Consultation Response from KC, Conservation and Design
2021/90350 153, West End, Netherthong, Holmfirth, HD9 3EJ
Erection of single storey side extension to dwelling and extension to detached garage to form garden room (within a Conservation Area)
Date Responded: 4.3.21
Responding Officer: Sue Oakley
Responding Ref:

Drawing title
Proposed Elevations

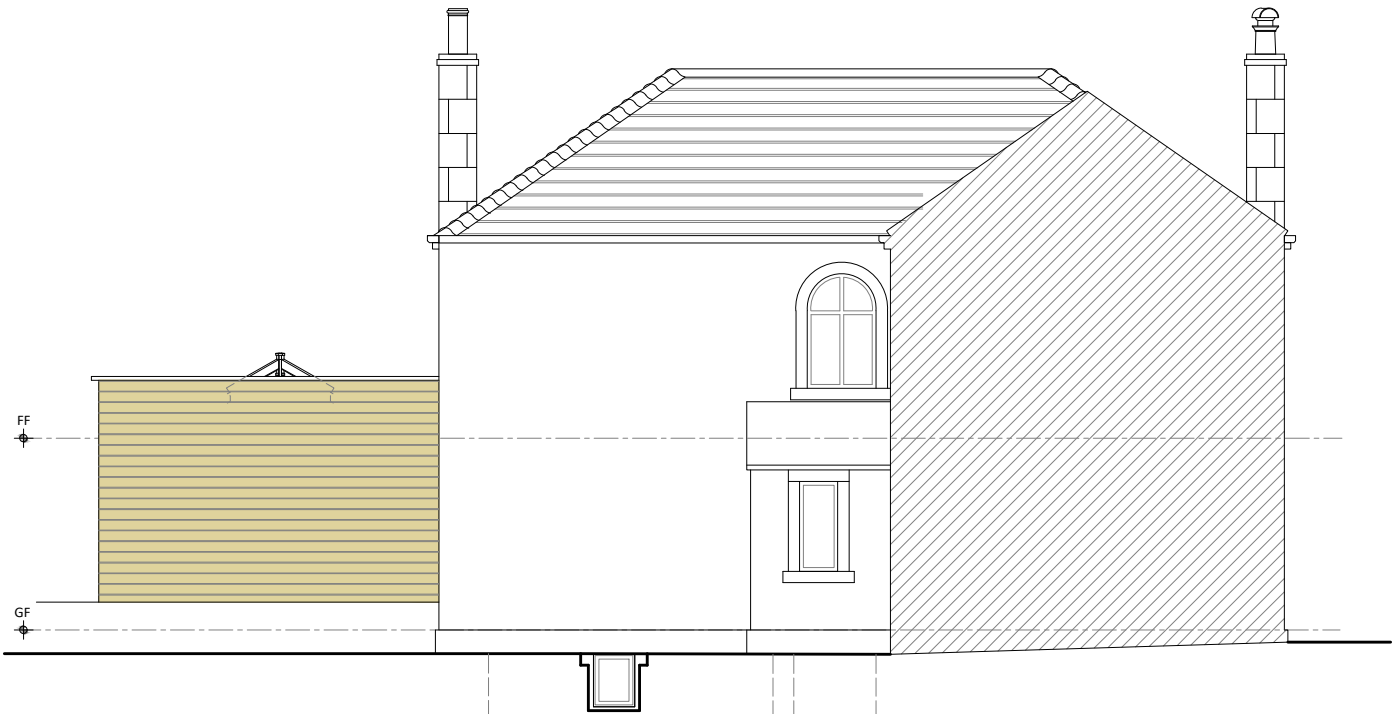
Parapet details should be carefully designed to ensure high quality detailing and these details should be submitted for approval as this is unclear from the drawings.
